Online Comment

Application H09-0721-25
Location Land South of Wignals Gate Holbeach Spalding
Proposal Development of 57 Affordable Dwellings with associated access, open space and drainage.

Date Submitted 11-10-25
For/Against Objections

Project	Wignal's Gate, Holbeach
Status	Planning
Client	D Brown Building Contractors
Package	n/a
Sheet Title	Boundary Treatment Plan
Scale	1/500 @A1
Date	19_02_25
Drawn by	LEN
Checked by	DNW
Drawing reference	102-575 / 006
Revision	A

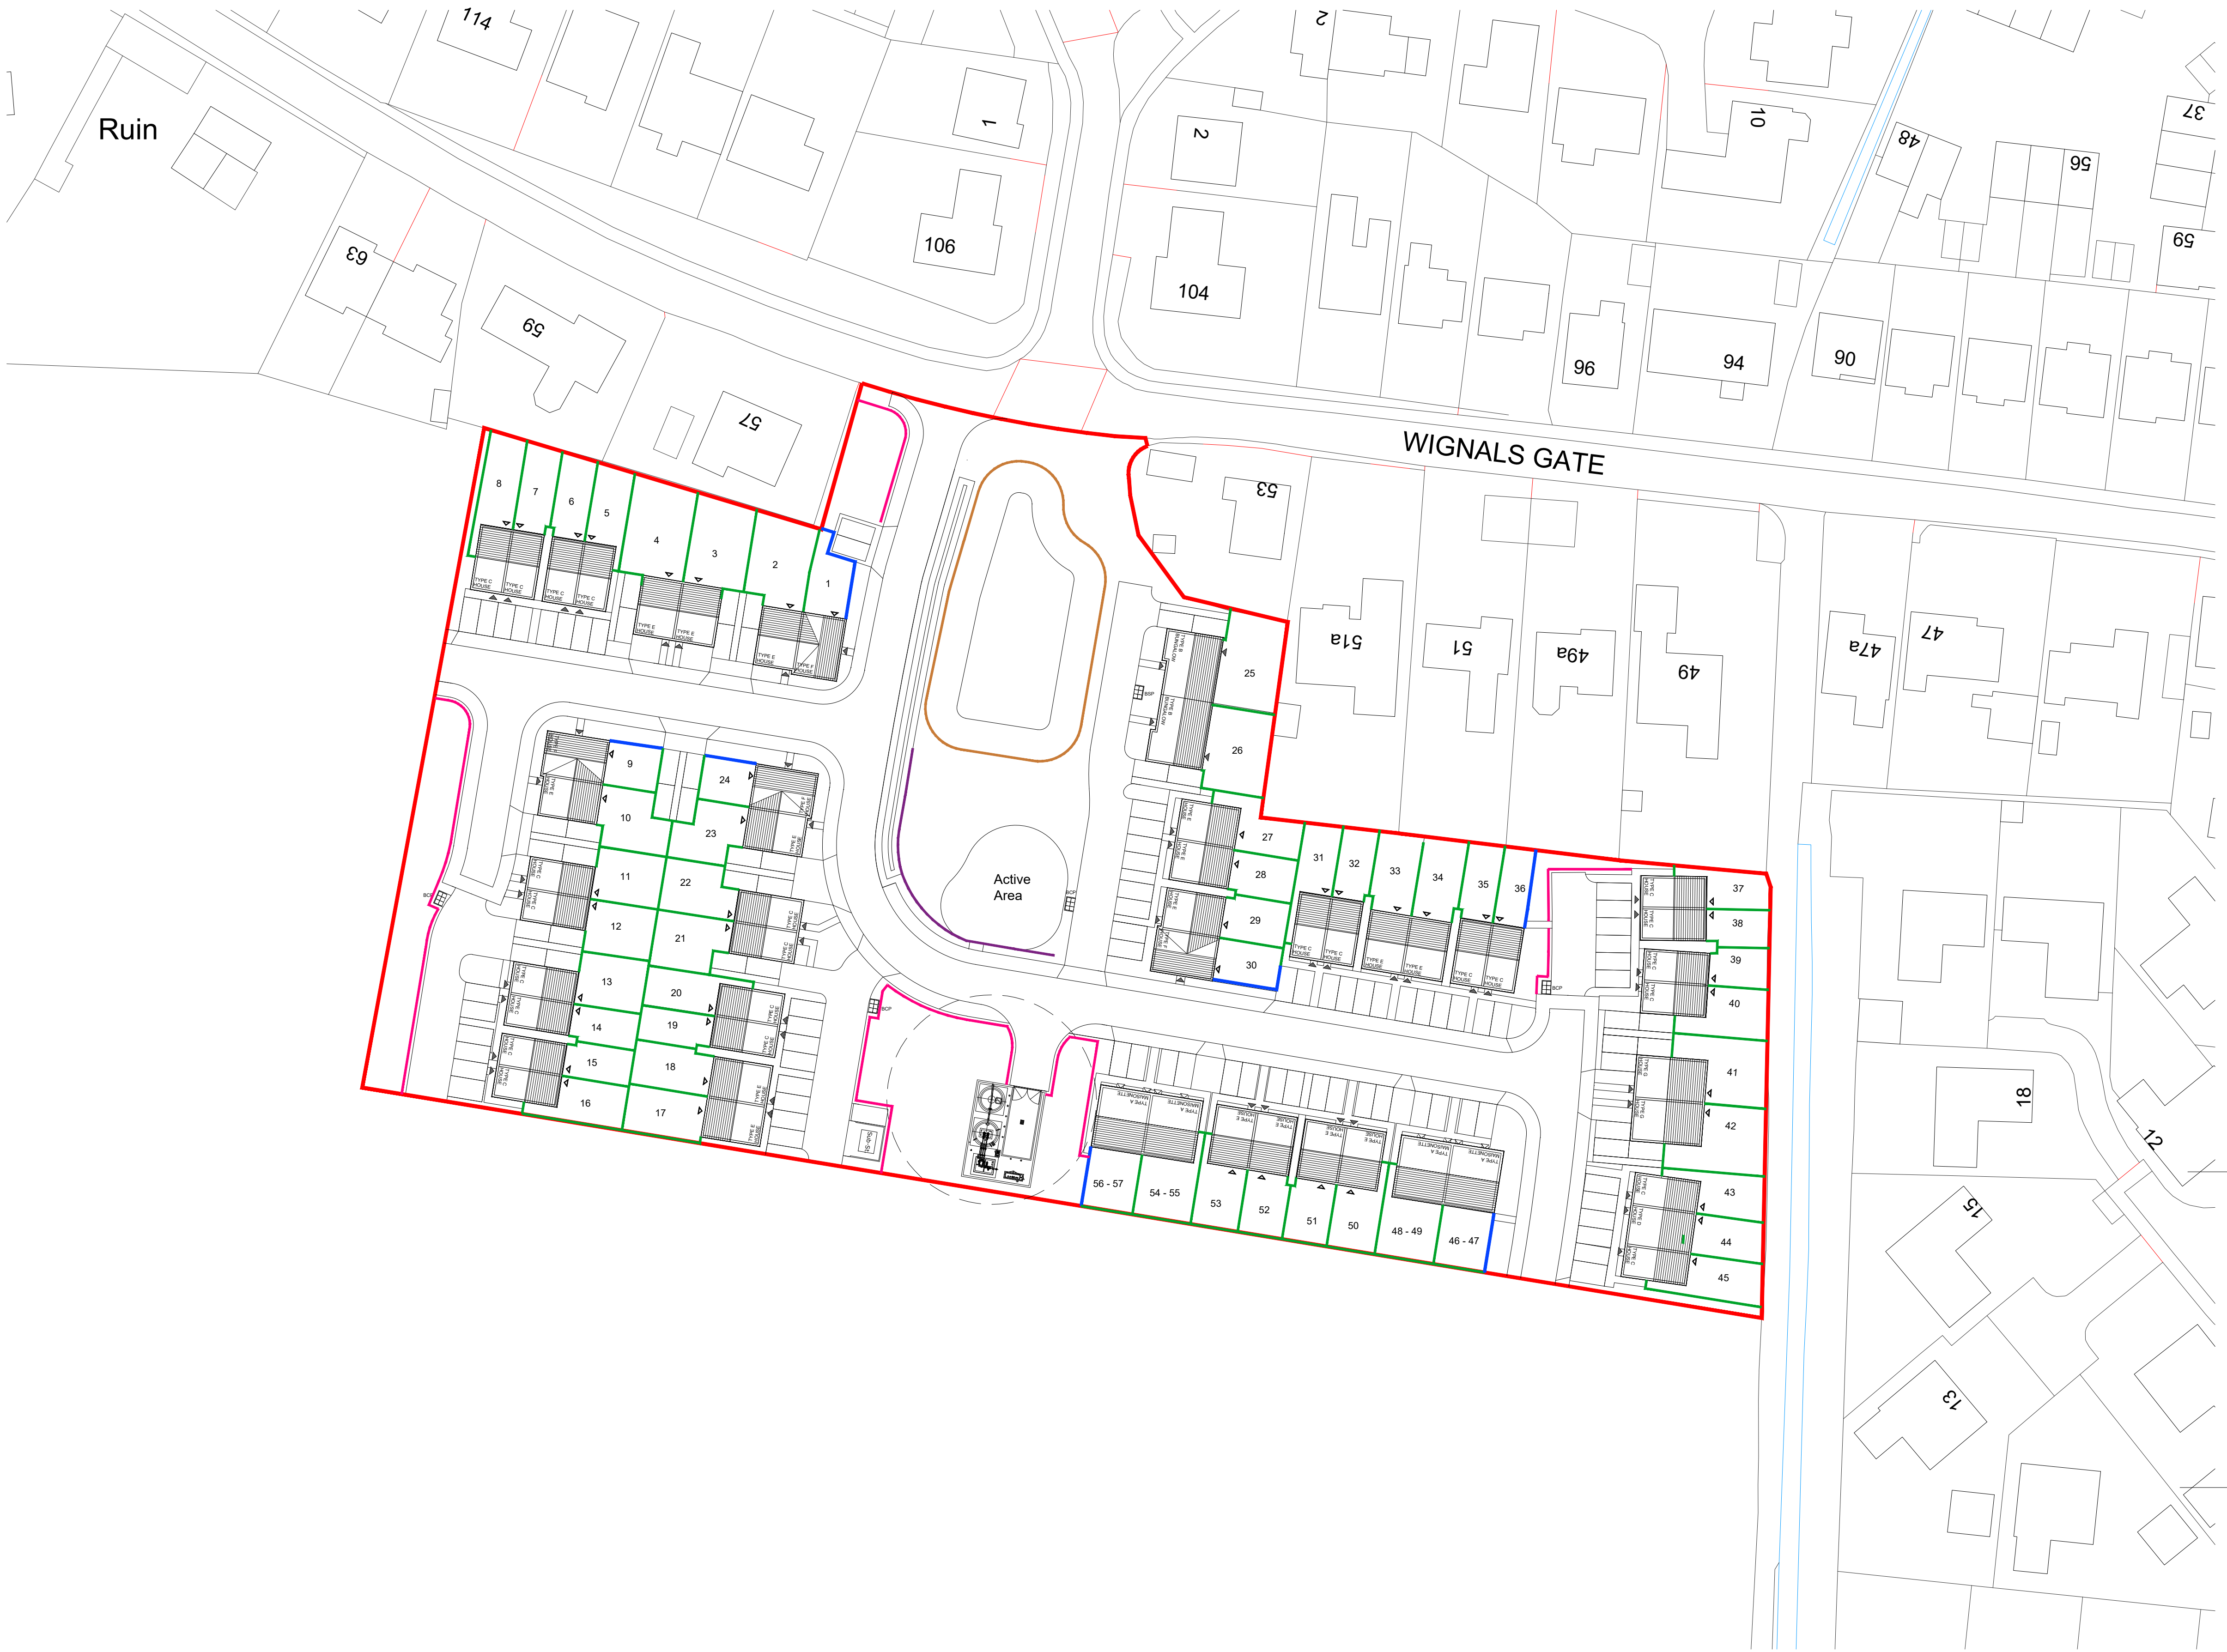
The proposed layout, with large expanses of close-boarded fencing, hard tarmac surfaces, and abrupt street endings, fails to respect the rural character and does not provide a natural transition to the countryside.
